Contact Officer: David Ongkili - 9093 6793
Your Ref: MP10_0044_MOD2

30 August 2017

SUBJECT LAND: 100-120 King Street and 30-36 Dangar Street, RANDWICK NSW 2031.
APPLICATION NO: MP10_0044_MOD2
PROPOSAL: S 75W Modification To Include FEAR No8 and other amendments

DRAWING TITLE
BLOCK D ELEVATIONS

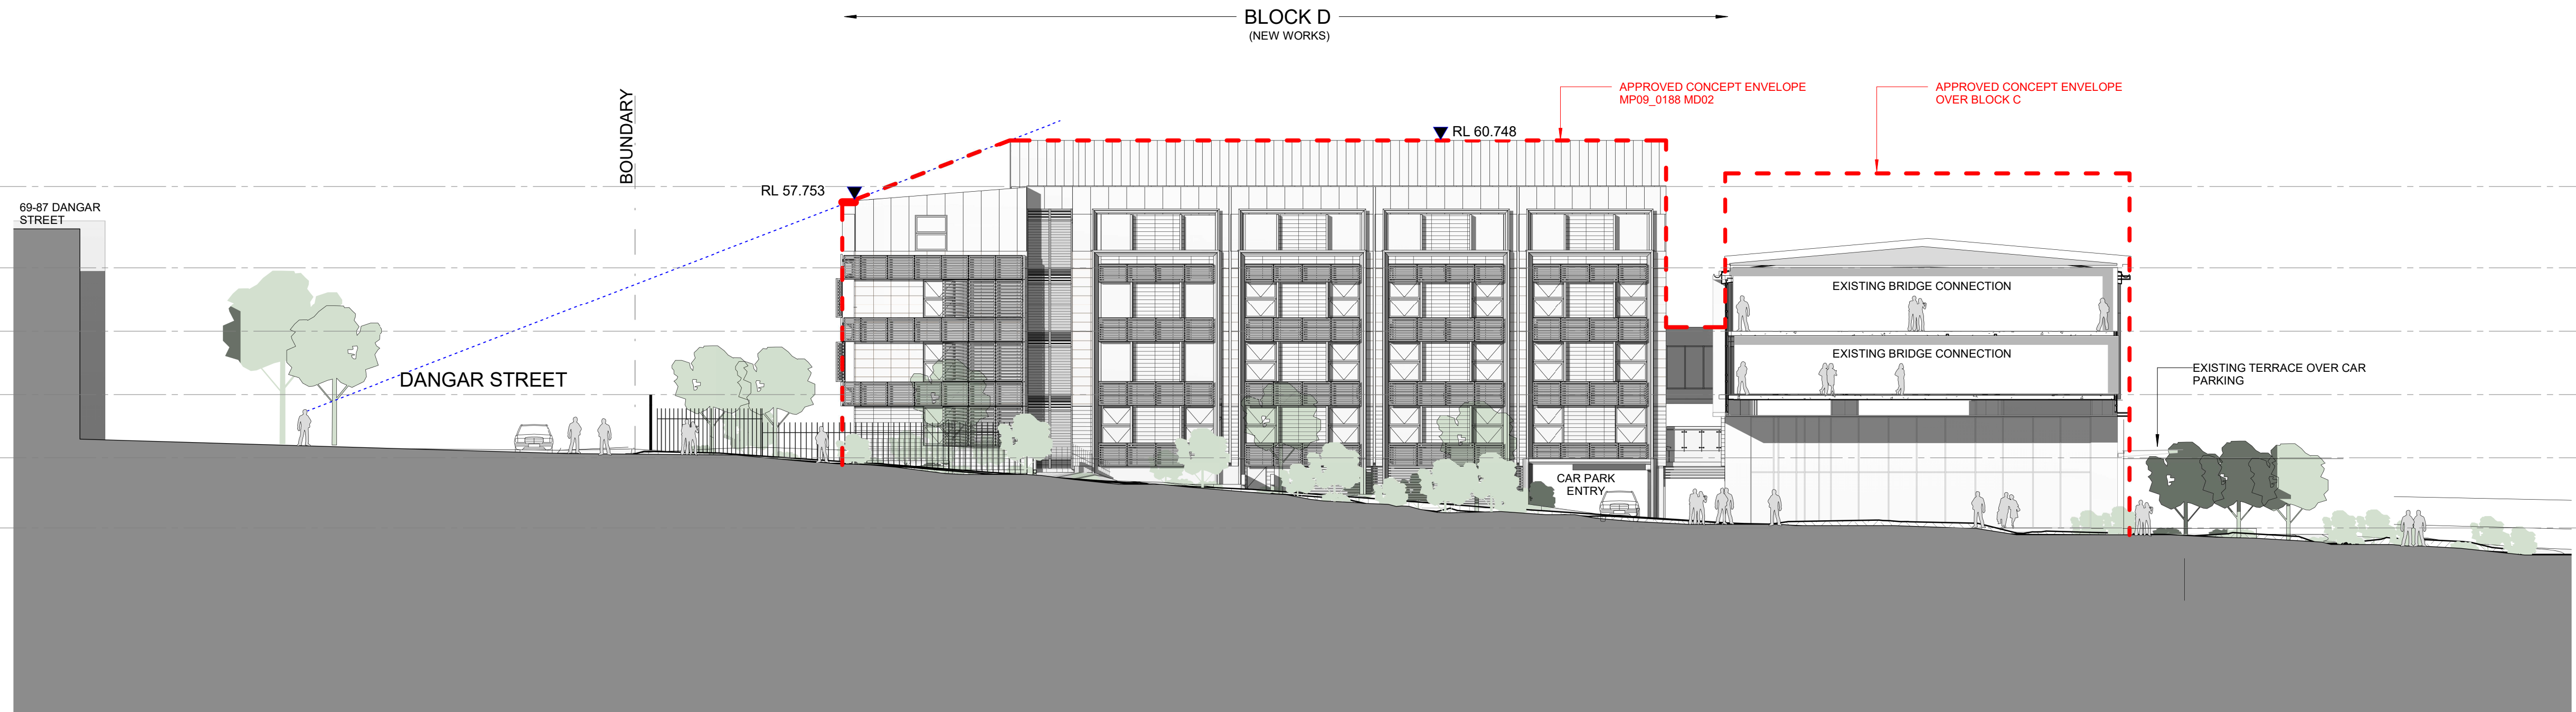
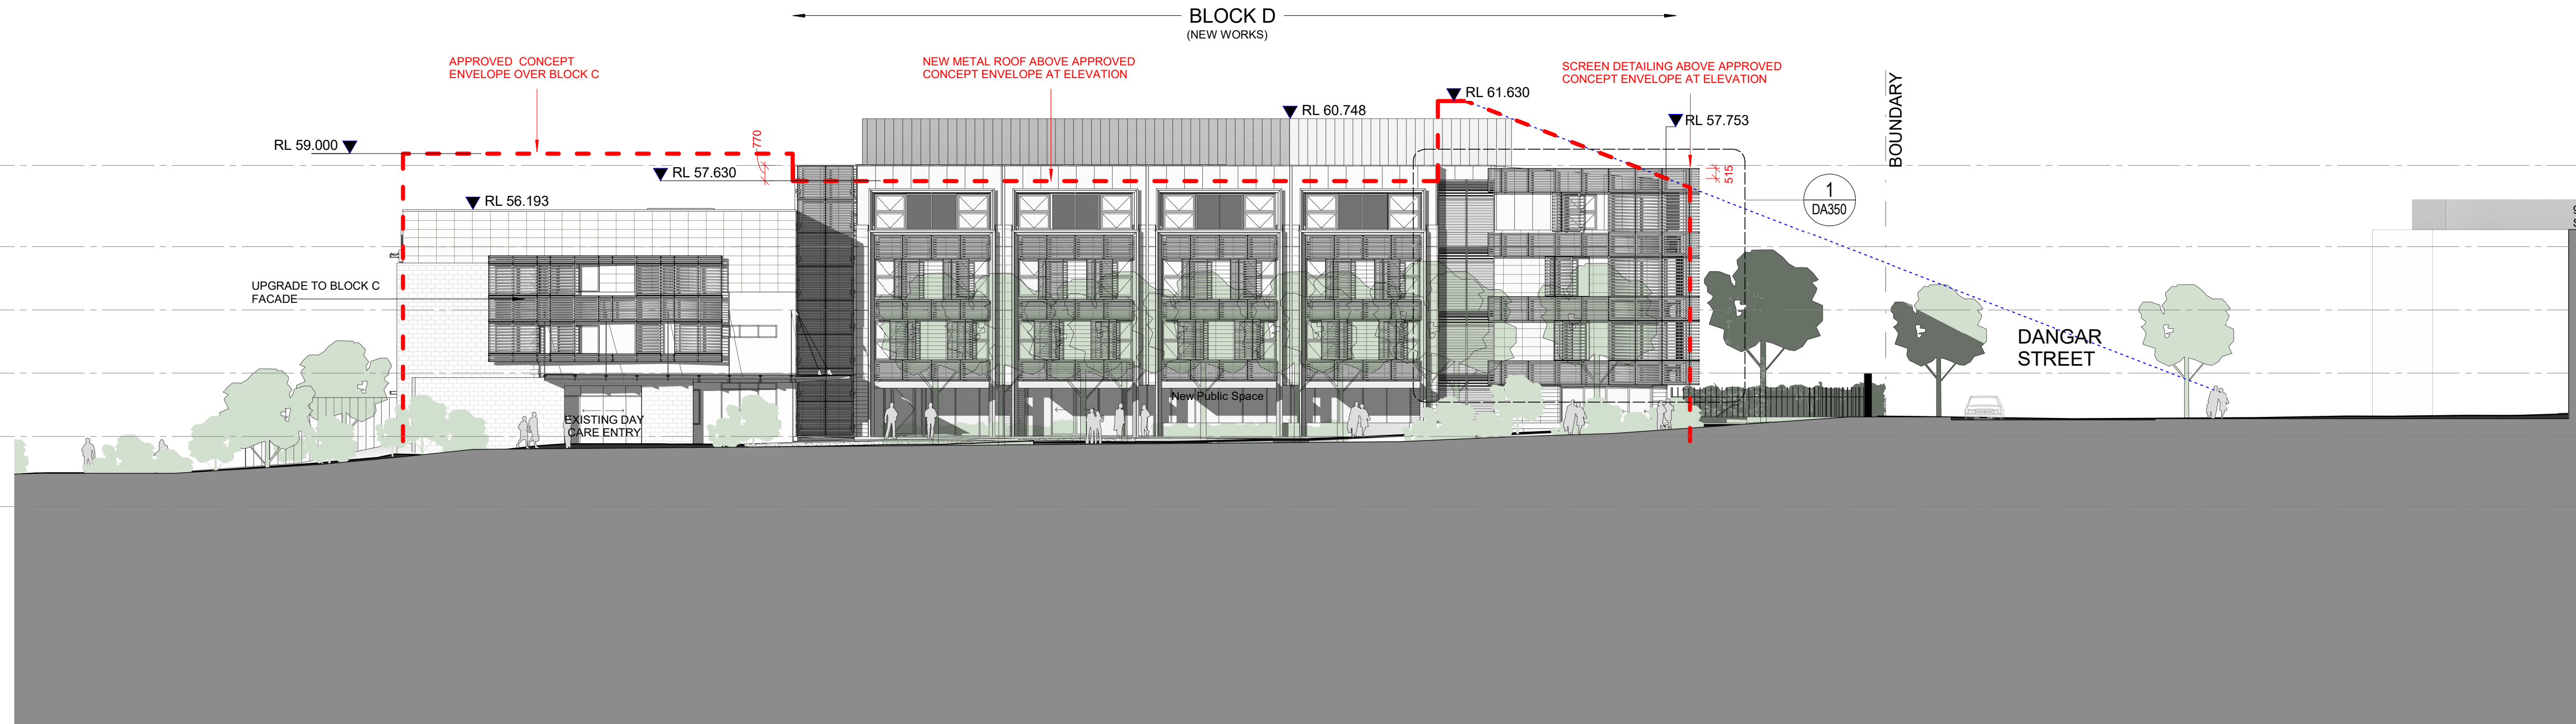
I refer to the Response to Submission (RtS) letter (MP10_0044_MOD2) prepared by Urbis and dated 4 August 2017. Following an assessment of the letter, please be advised that Council maintains its concern regarding the modification to Building D, in particular, the increase in height along King Street and Dangar Street and the potential loss of retail space.

Council is fully aware that the additional level (Level 7) was approved under Concept Plan amendment (Mod 2) and, in Council's first submission, clearly acknowledged that Level 7 had an absolute maximum height compliant with the approved maximum building height of RL61.63 for Building D. Council is also cognisant of the role of the current Section 75W for Building D, that is, primarily, to enable the approved modifications under the Mod 2 Concept Plan. It is in this context, that Council stated, and reiterates, its position that the

proposed built form for Building D as approved under the modification approval MP09_0188 MOD 2, will be overbearing, dominant and intrusive upon the existing medium density scale of the town houses and apartments in Dangar Street and the two-storey mixed use and residential development in King Street. It was in recognition of this concern that the PAC imposed FEAR No. 8. It is ironic therefore that the visual relief gained by the top-level building setback under FEAR No. 8 will now be negated by the proposed introduction of the 770mm parapet protrusion along King Street and the 515mm façade screen protrusion along Dangar Street. The proponent refers to these protrusions as minor. However, Council maintains that the incremental increase in these areas are unacceptable as they add to the visual bulk of Building D. Specifically, a 770mm protrusion to accommodate a roof element is considered excessive and a much lower roof profile should and can be applied to address the roof drainage issues. Similarly, the introduction of a 515mm façade screen simply to provide "visual interest" runs counter to the PAC's original visual mitigation objective under FEAR No. 8. Its description as a "facade screen" is erroneous because it serves no visual screening purpose given that the proposed plant room on this level will be recessed within the building envelope and not visible from street level. Accordingly, Council's position is that, if the dementia units and their associated terrace areas have now become "redundant" under FEAR No. 8, then Level 7 should be left unoccupied and become a permanent low profile roof level. The parapet and façade screen protrusions serve only to pre-empt and keep alive prospects for further levels to be added in the future and this, precisely, is Council's concern regarding 'development creep' in the Montefiore development.
